# CITY OF ALBUQUERQUE

March 8, 2024

**Re: Circle K**  
**10850 Golf Course Rd. NW**  
**Traffic Circulation Layout**  
Engineer's Stamp 03-01-24 (A12-D008B1)

SP01

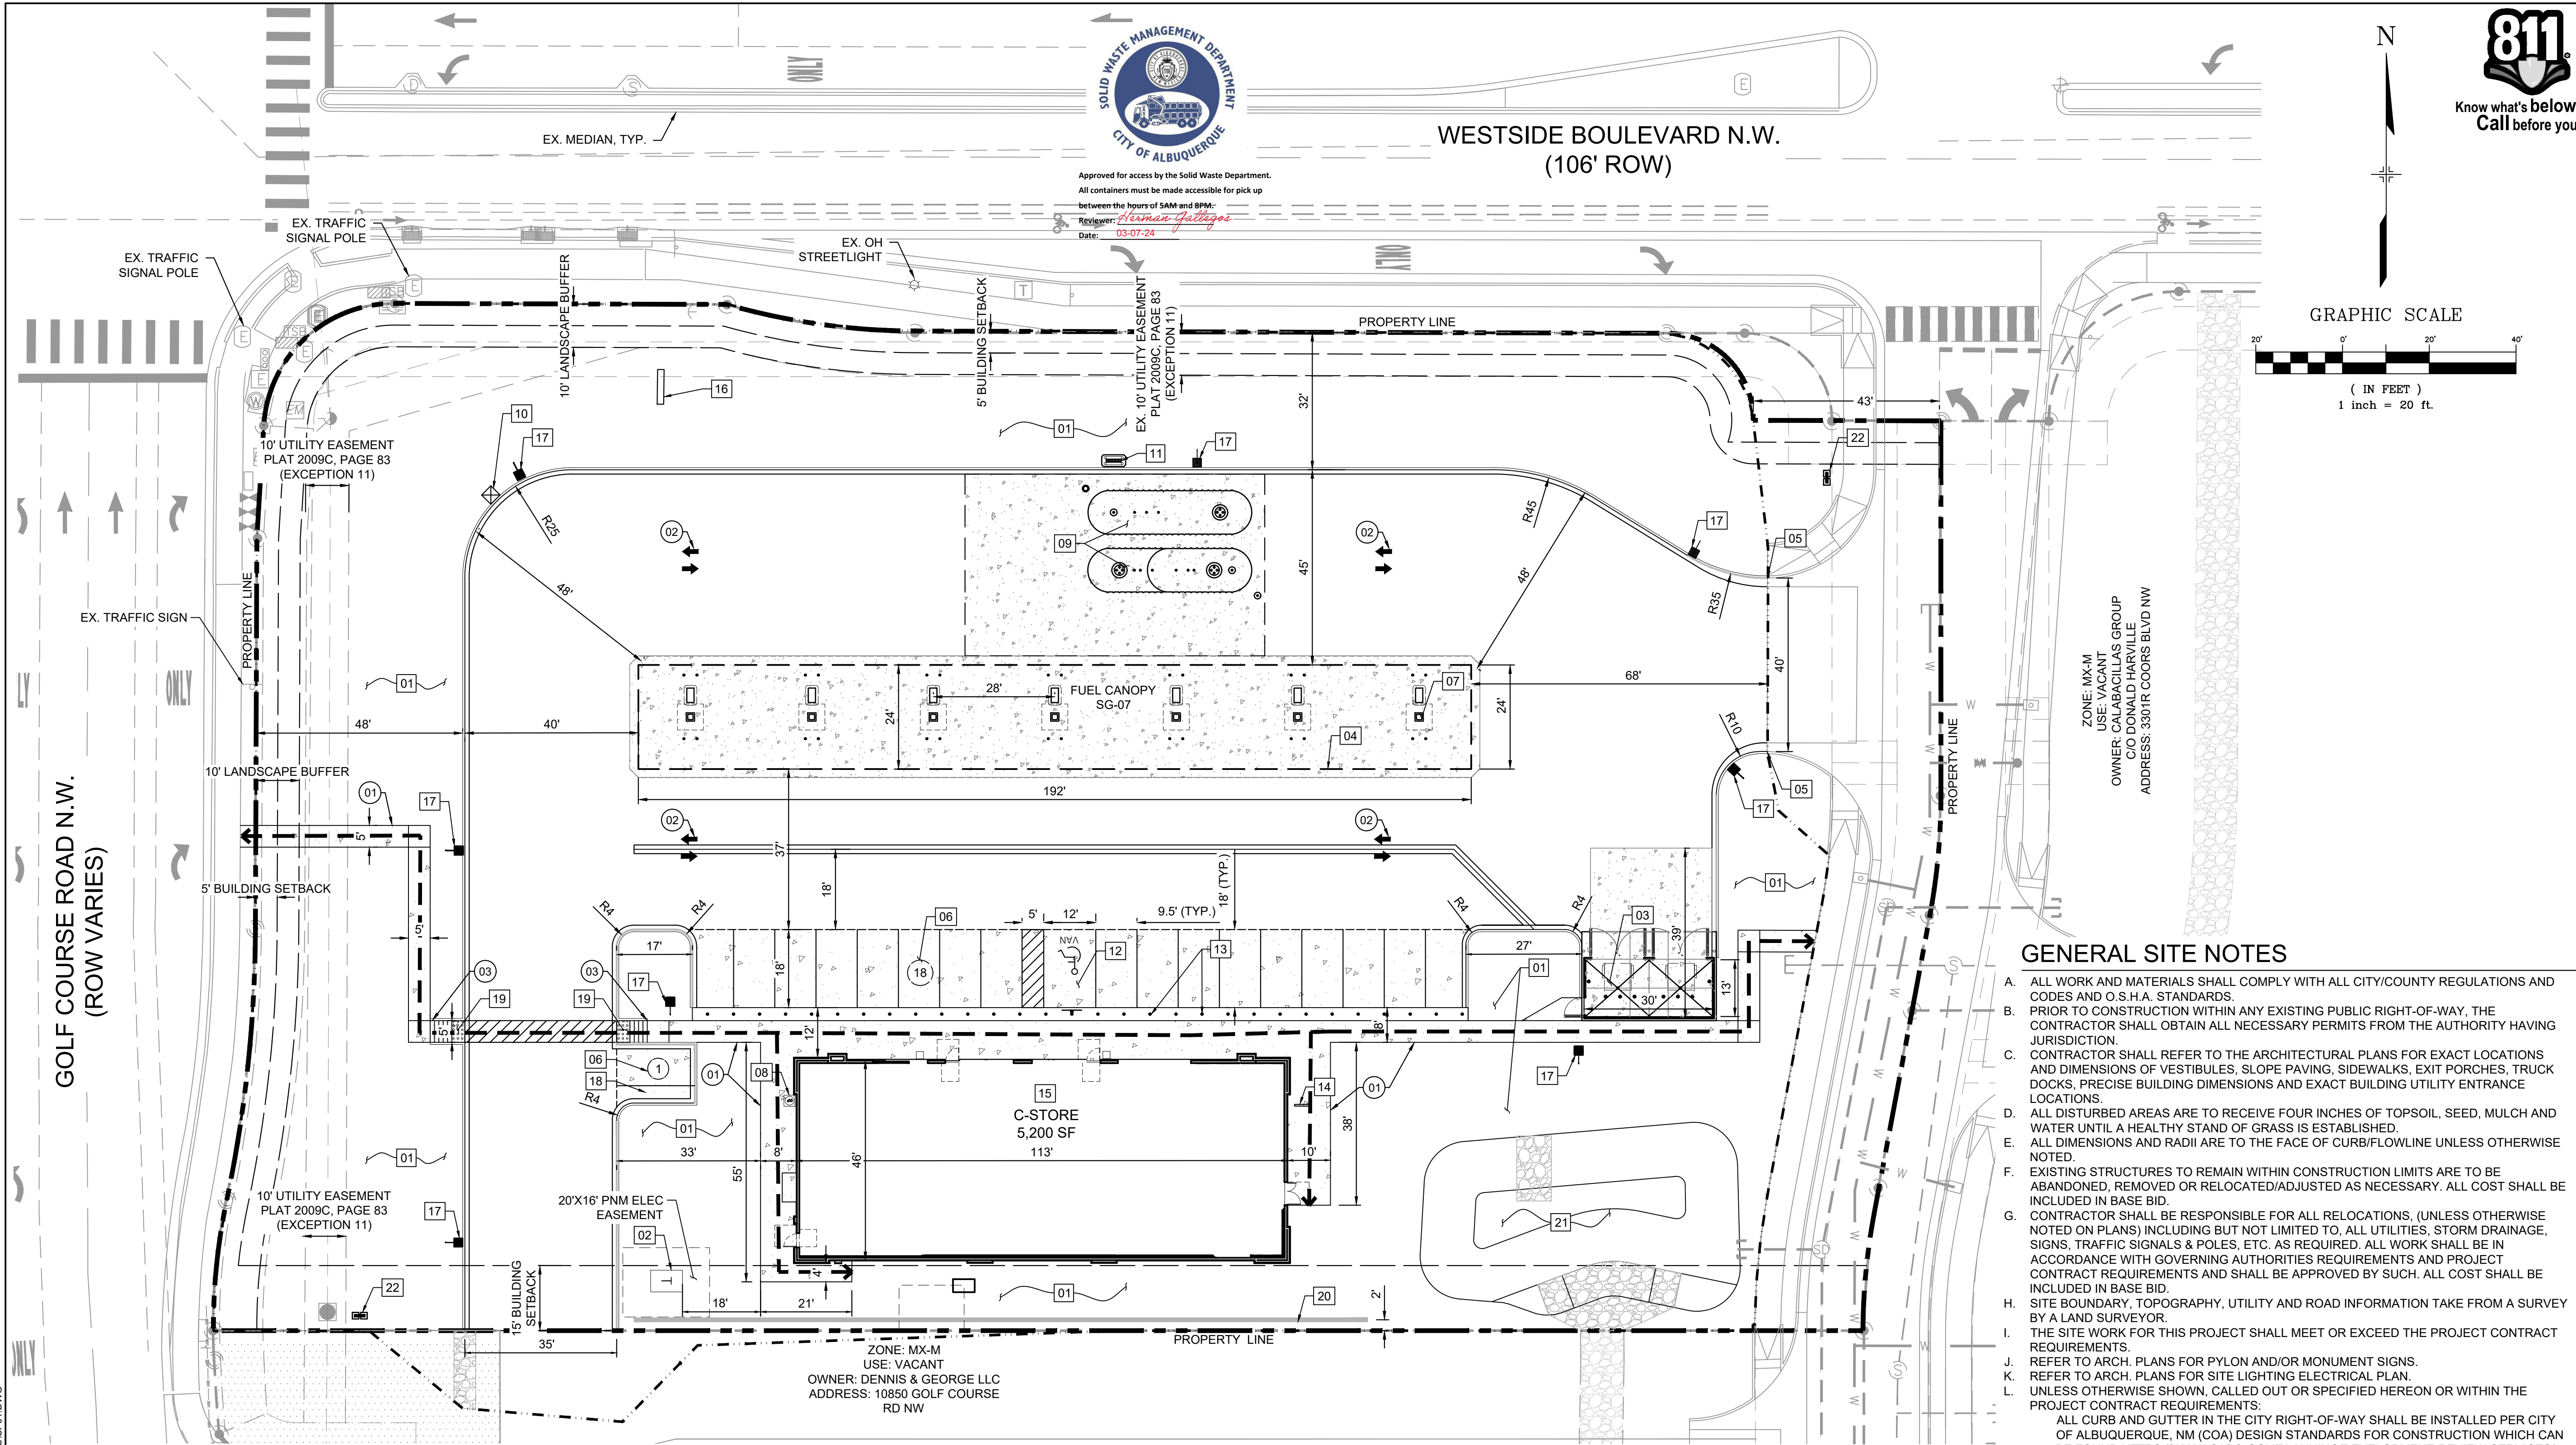
2. List the number of parking spaces required by the IDO as well as the proposed number of parking spaces including bicycle and motorcycle parking. *Matrix: A table has been added to SP01 with the required parking.*

3. Identify all existing access easements and rights of way width dimensions. *Matrix: Access easements and ROWs have been labeled.*
4. The ADA access aisles shall have the words **"NO PARKING"** in capital letters, each of which shall be at least one foot high and at least two inches wide, placed at the rear of the parking space so as to be close to where an adjacent vehicle's rear tire would be placed. (66-1-4.1. B NMSA 1978) *Matrix: "NO PARKING" pavement marking now proposed.*

6. Show the Intersection clear sight triangle at the site access off Westside Blvd. *Matrix: The sight triangle was shown on the Landscape Plan and is now added to the Site Plan.*
7. Provide a copy of approved recorded plat. *Matrix: To be provided by LDC.*
8. Provide a copy of Fire Marshal and Solid Waste approval. *Matrix: To be provided by LDC.*
9. An approved TIS is required prior to approve the TCL for building permit. *Matrix: To be provided by LDC.*
10. Please provide a letter of response for all comments given.
